September 5, 2017

Re: 12 Alder Street Repair Narrative

4 TYPICAL NEW SIDING DETAIL AT EXISTING WALL  
1/4" = 1'-0"

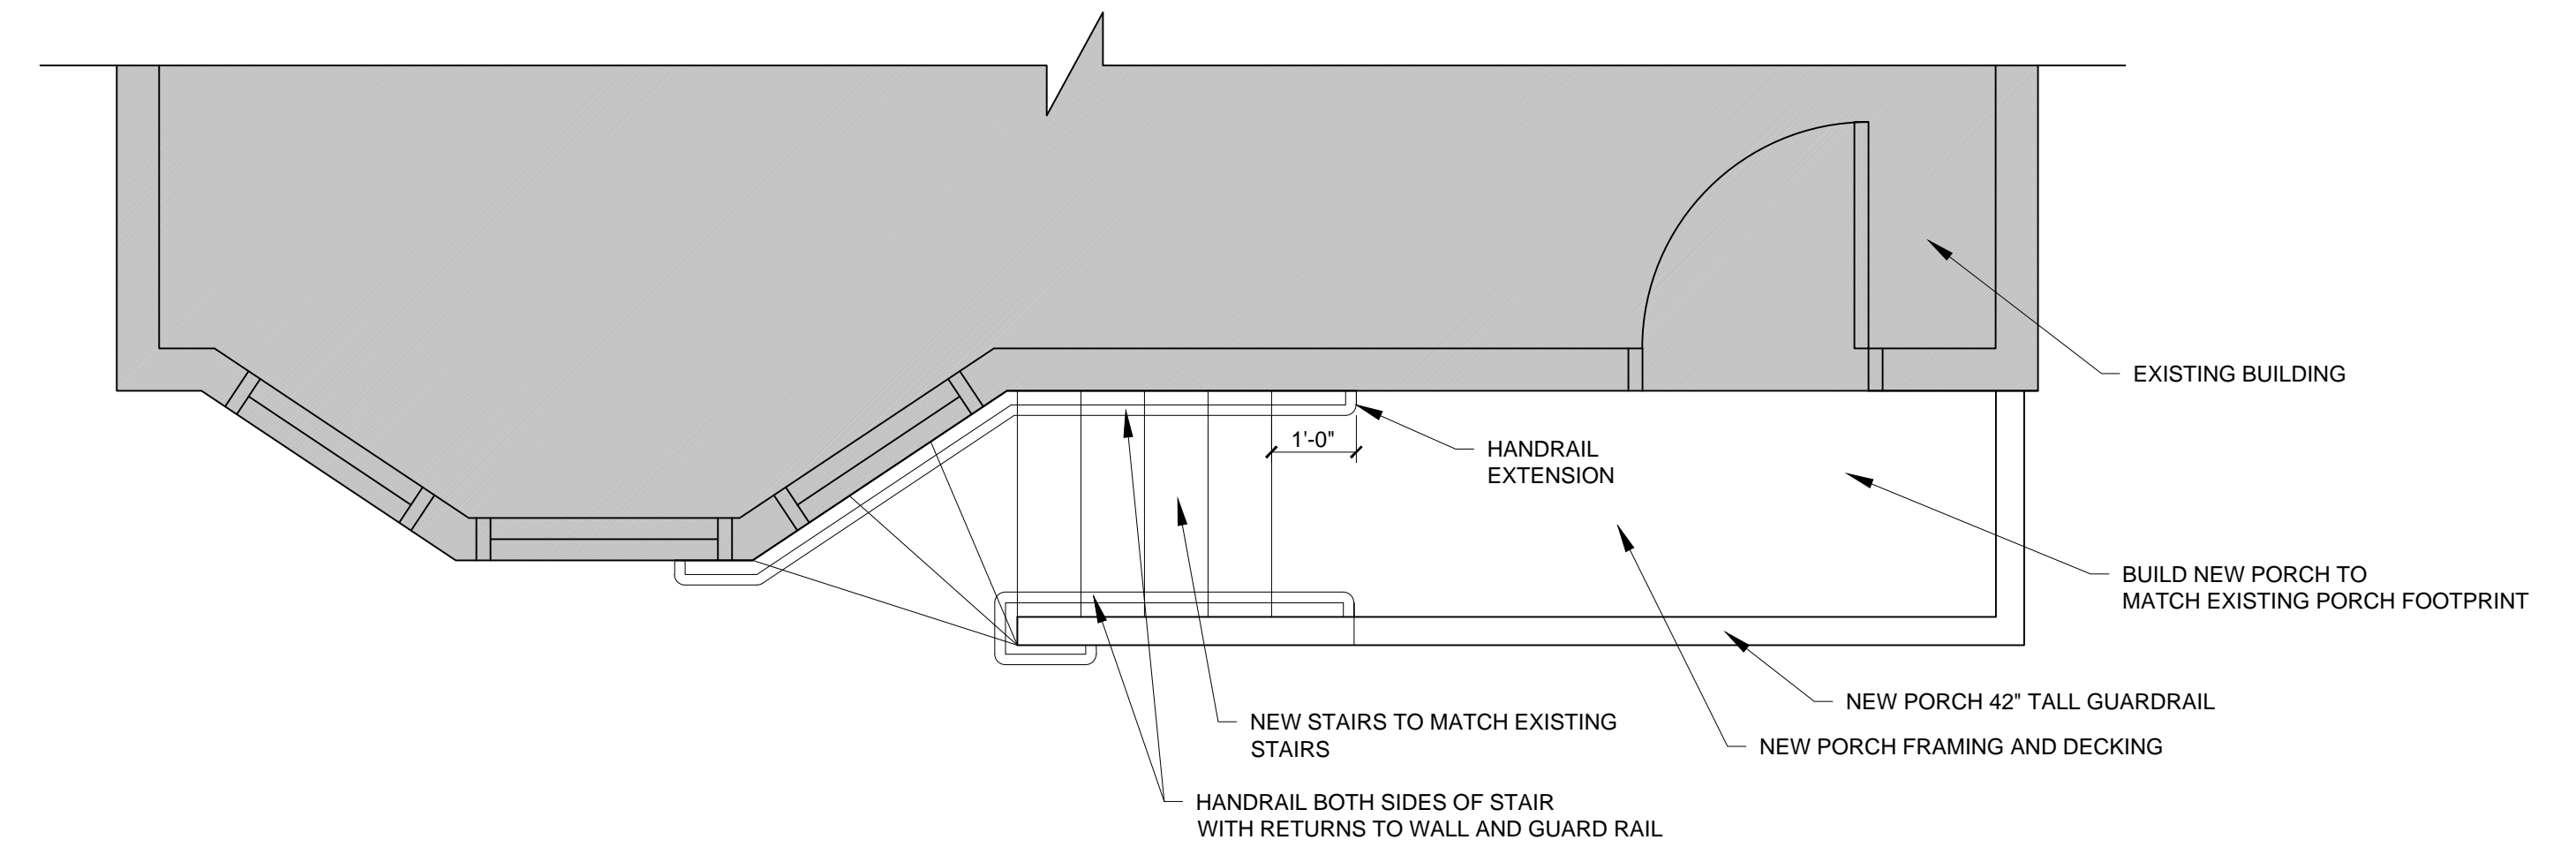
9.) Install fiber-cement siding on the Alder Street elevation where the existing (non-vinyl siding exists). Ensure all areas of missing siding are covered by the new siding and weathertight. See the typical siding detail attached

1 PORCH ELEVATION  
1/2" = 1'-0"

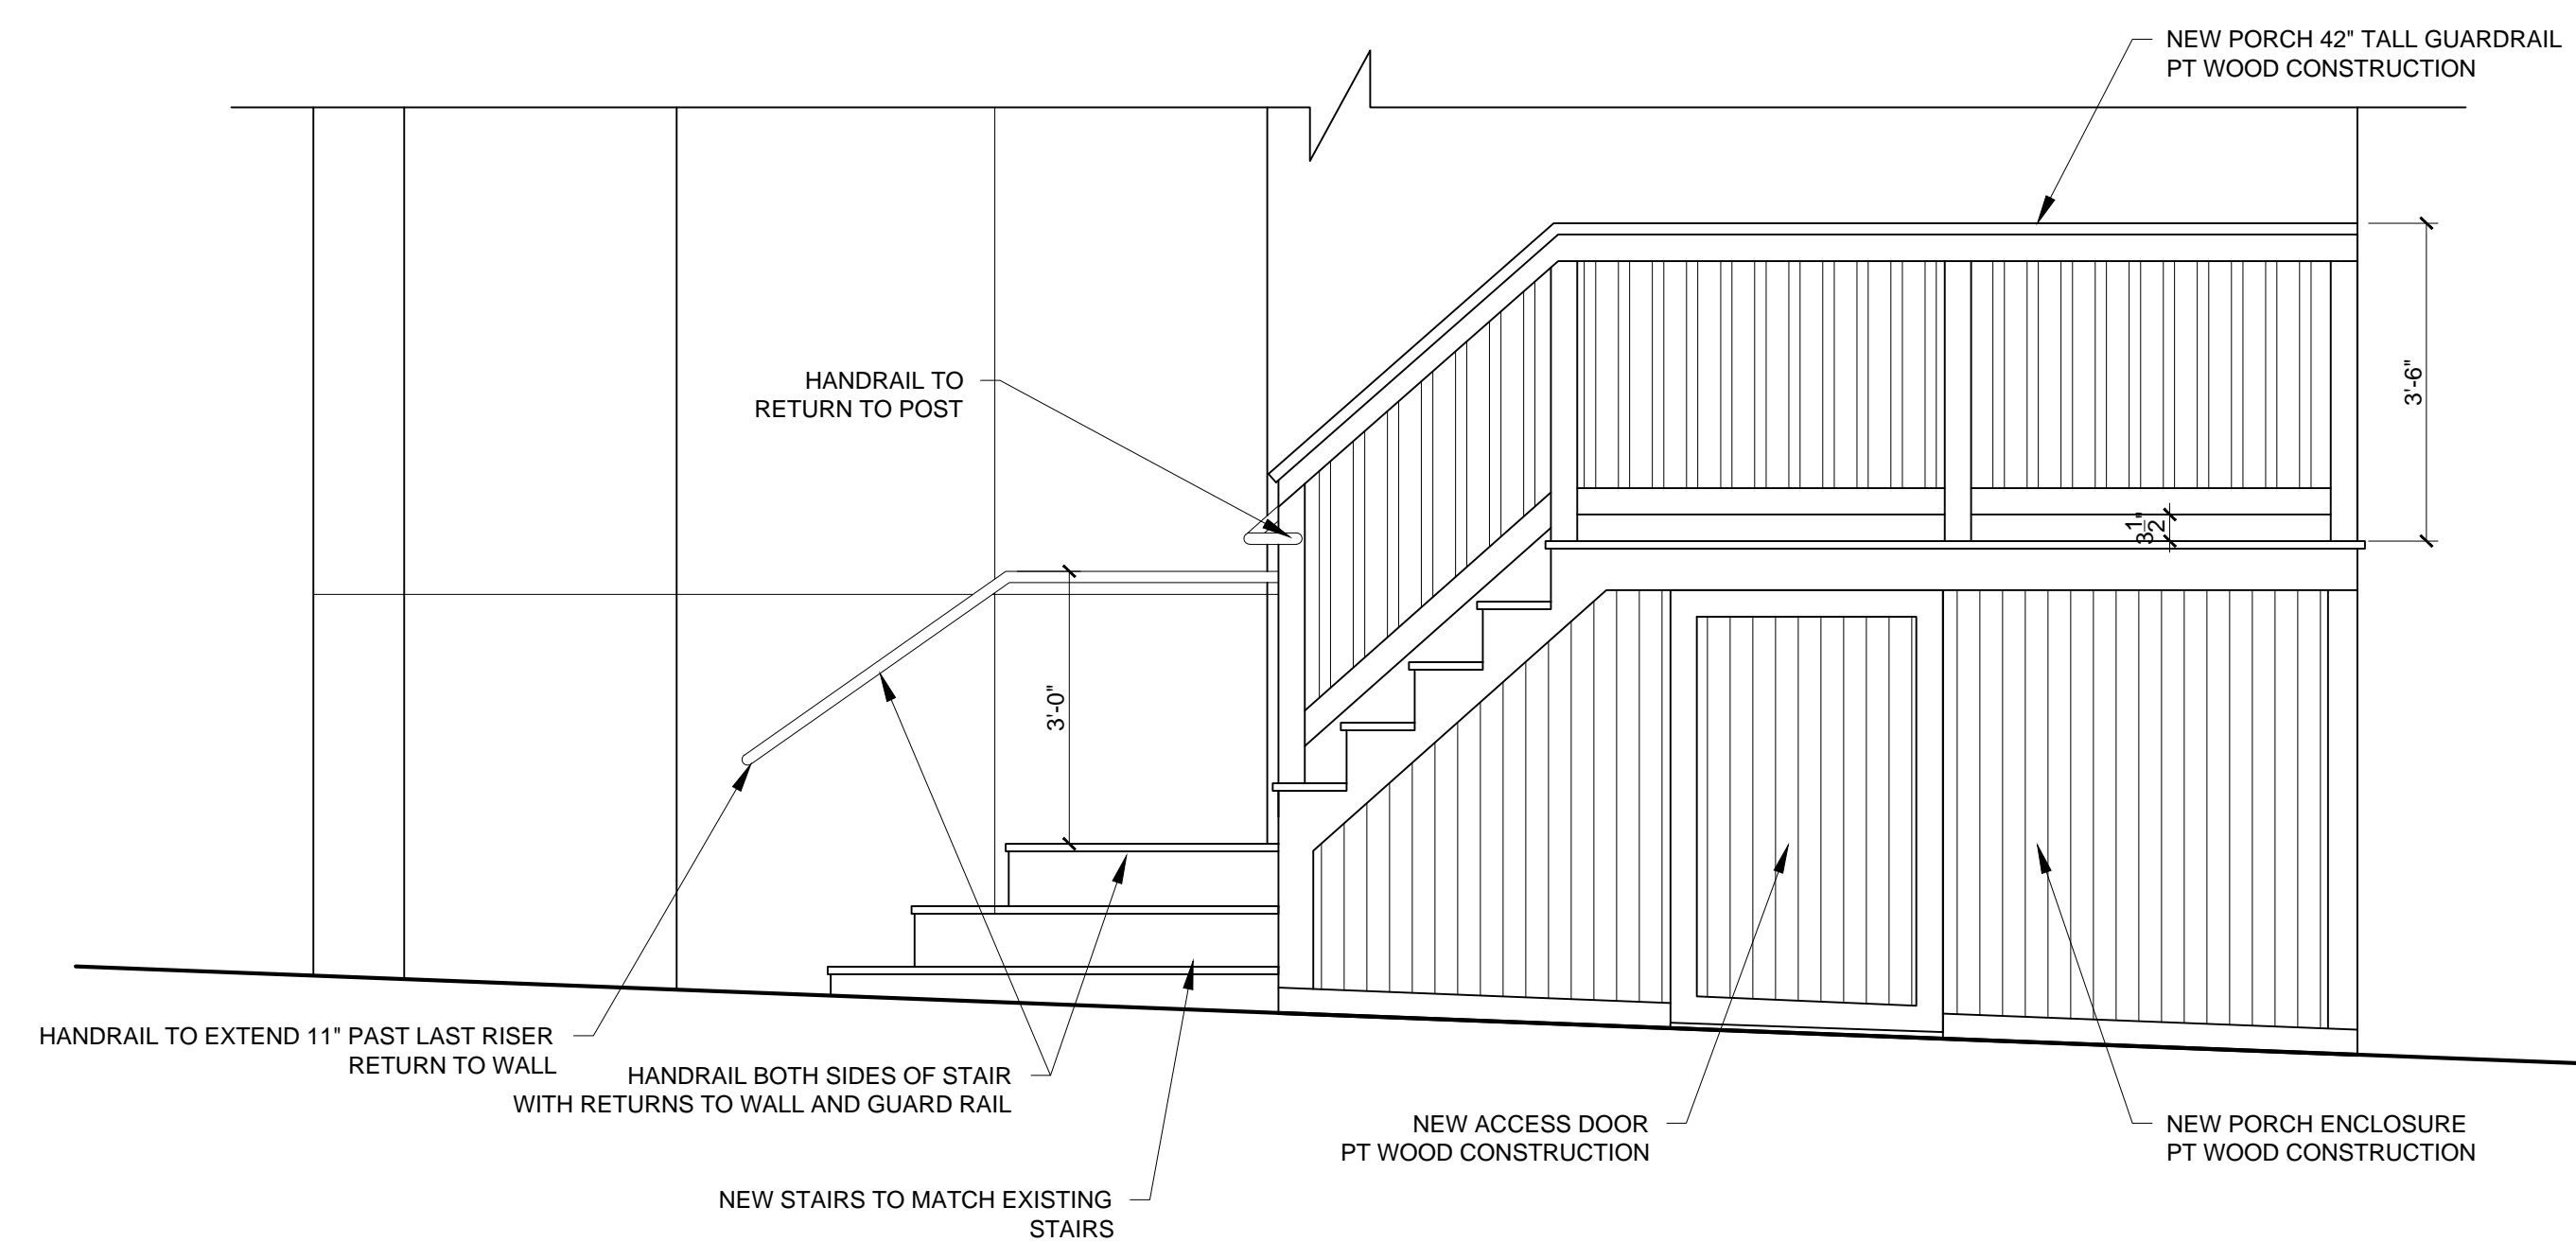
- 1.) Fasten and secure any loose vinyl siding
- 2.) Secure all decking boards at rear deck
- 3.) Install handrail as rear deck
- 4.) Install flashing on all windows where flashing is missing, to provide weathertight and positive drainage around windows and out over siding.
- 5.) The property owner intends to check all other window flashing and replace them on an as needed basis over time.
- 6.) Remove and replace front porch roof overhang
- 7.) Remove and replace treads, risers, decking, handrails, guardrail and cladding at front porch. See front porch details attached.
- 8.) It was observed that the existing brick foundation has been repaired where previous holes existed
